From: Phil Wiltshire [REDACTED]
Sent: 04 November 2015 11:07
To: David Easton
Cc: [REDACTED]
Subject: RE: AW/267/15/HH - 68 The Drive, Aldwick

Subject: FW: AW/267/15/HH - 68 The Drive, Aldwick

From: David Easton [REDACTED]
Sent: 03 November 2015 09:23
To: Phil Wiltshire [REDACTED]
Subject: AW/267/15/HH - 68 The Drive, Aldwick

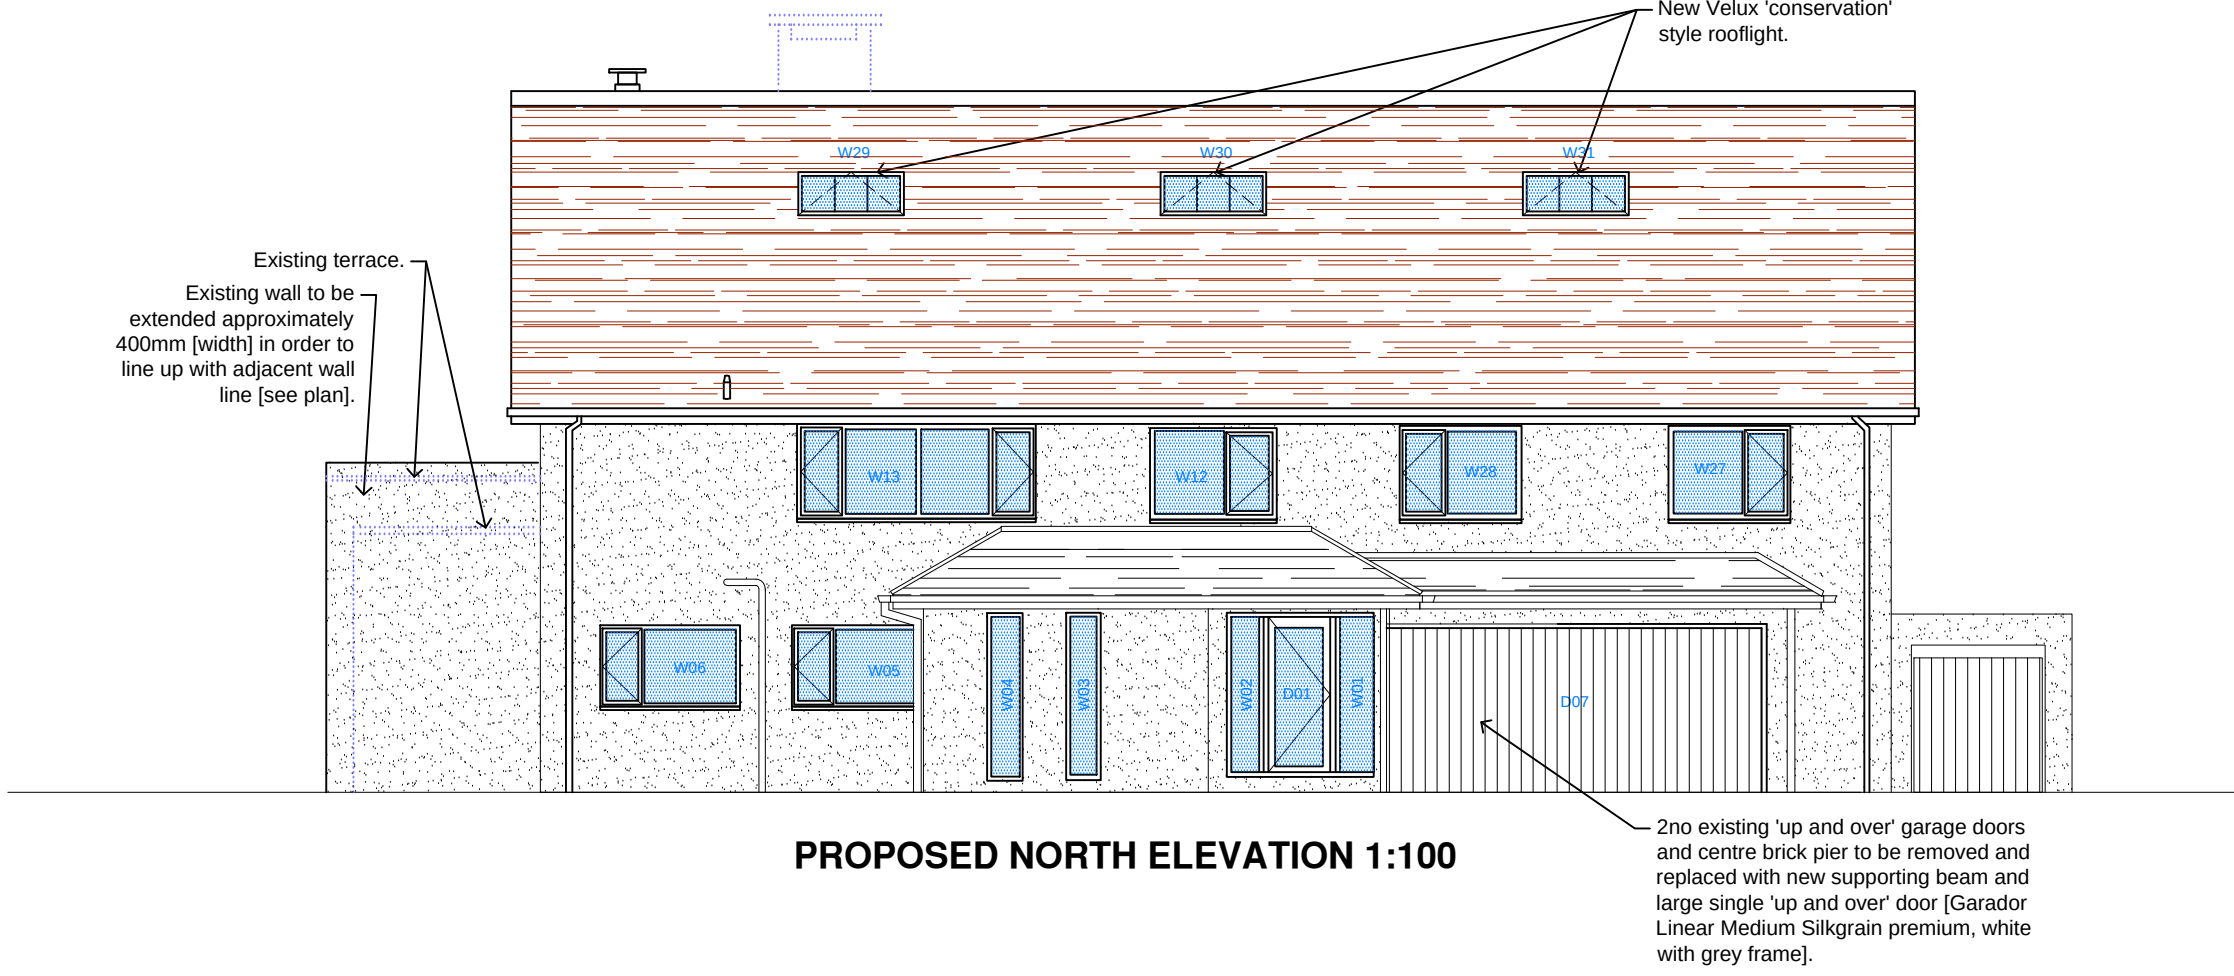
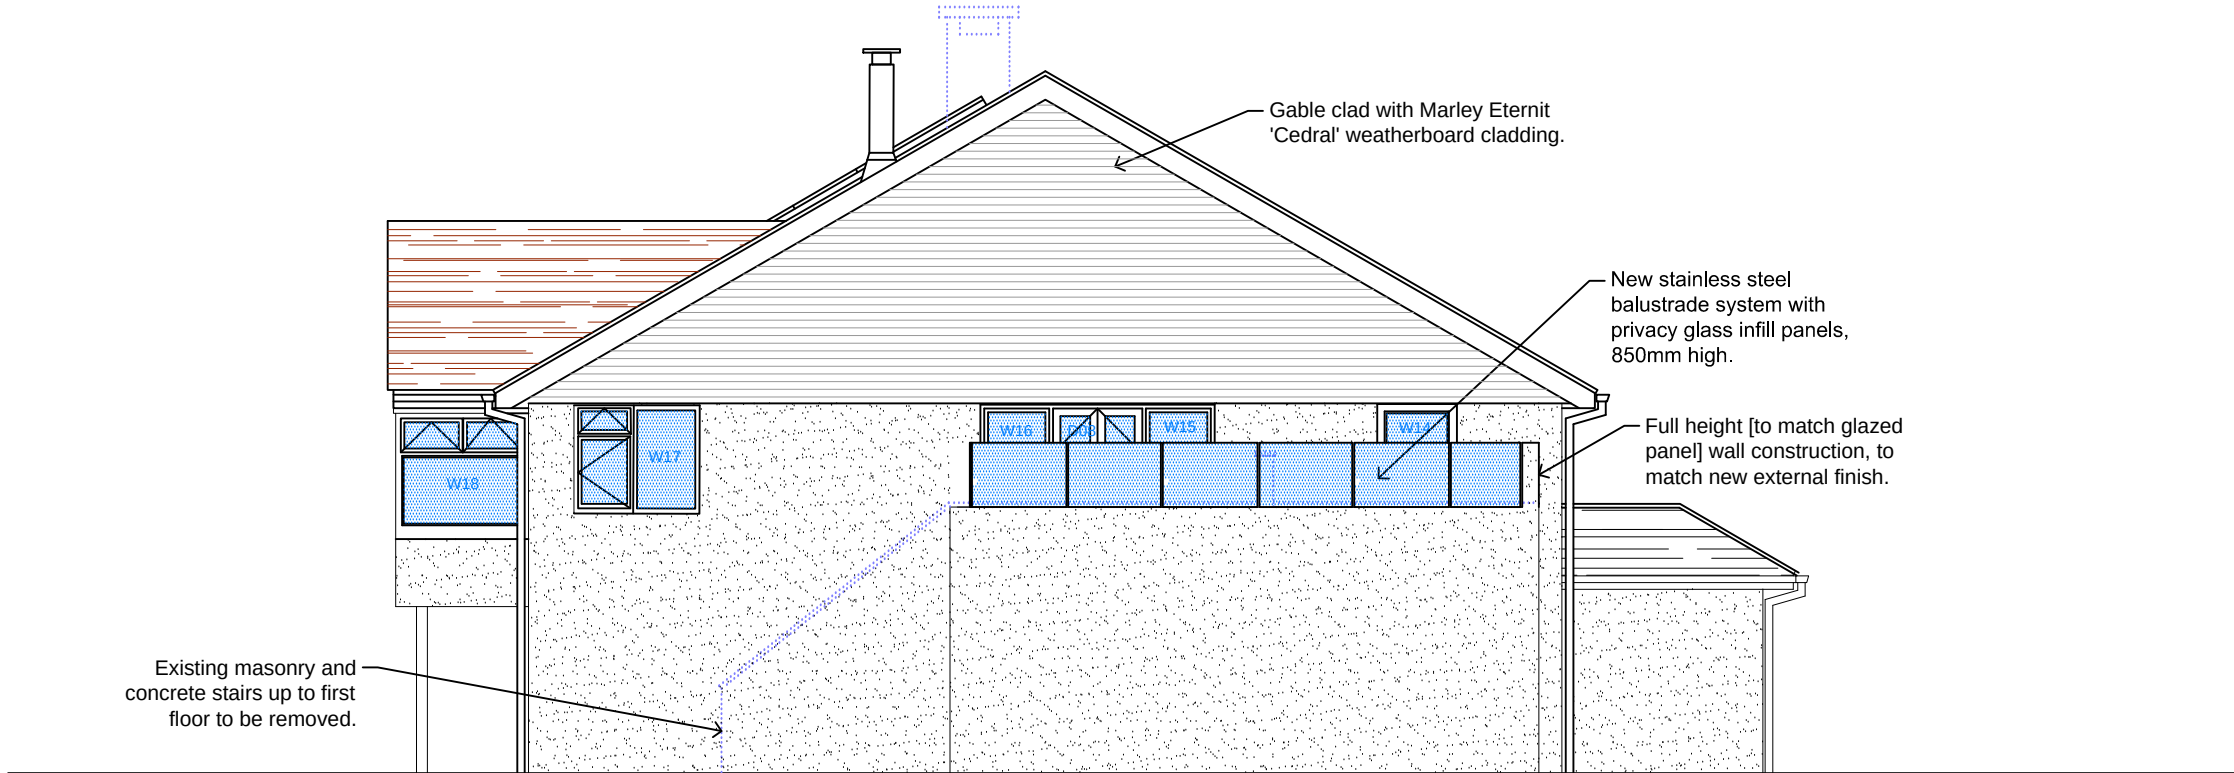
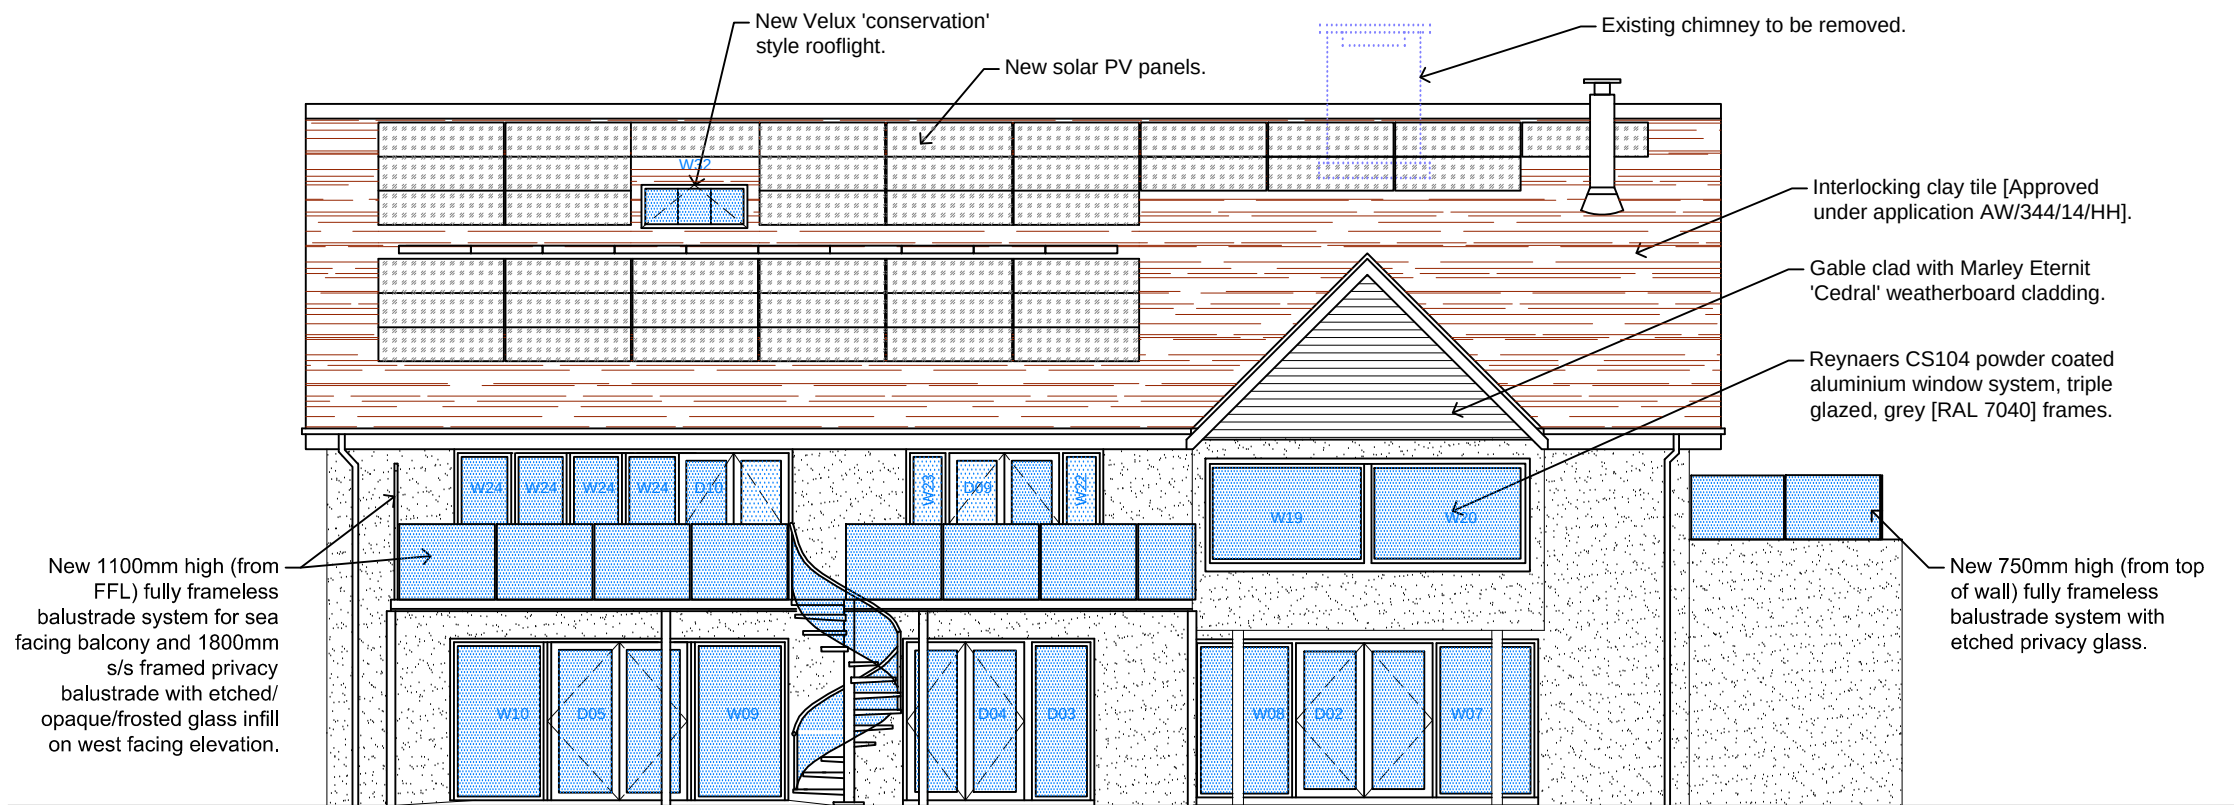
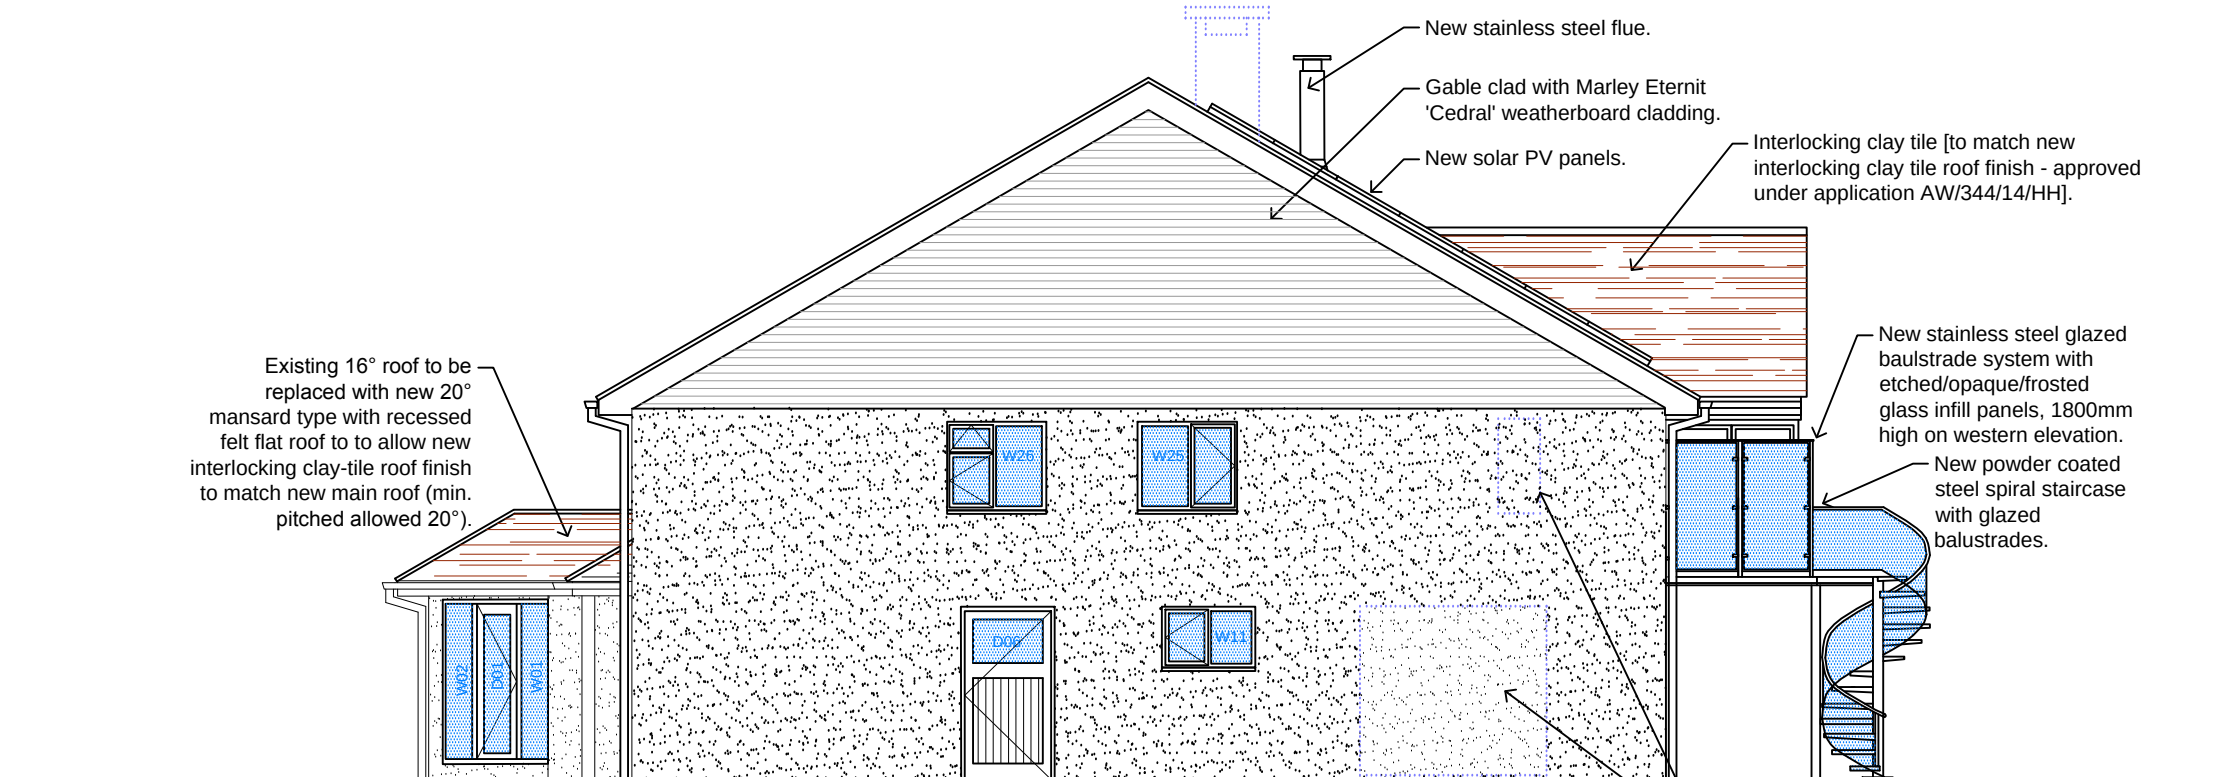
I have spoken with Mr White (Conservation Officer) who has confirmed that his concerns relate not only to the proposed palette of the building but also the materials. The weatherboarding is not considered appropriate or in keeping with the character of the Conservation Area. Therefore, tile hanging or more traditional materials already present within the Conservation Area would be considered an appropriate solution. The proposed roof tiles are considered appropriate and in accordance with policy AREA2 of the Arun District Local Plan given that they preserve the character of the Conservation Area and that of the existing property. Therefore, it will be necessary for all materials used in the construction of the dwelling to do the same.

- the downlights in the soffits
- the colour of the windows
- the weatherboarding

- Omission of the soffit led lighting (although we note that similar lighting is provided on other properties within the conservation area)
- Omission of the Eternit cladding to the main gables and southern gable
- Change from grey aluminium window and door frames to white

To facilitate these changes we have also shown a slight change of the render colour from the original approved colour of Limestone White to Wheaton noting the colour swatches are provided within appendix 13.2 as our original design statement.
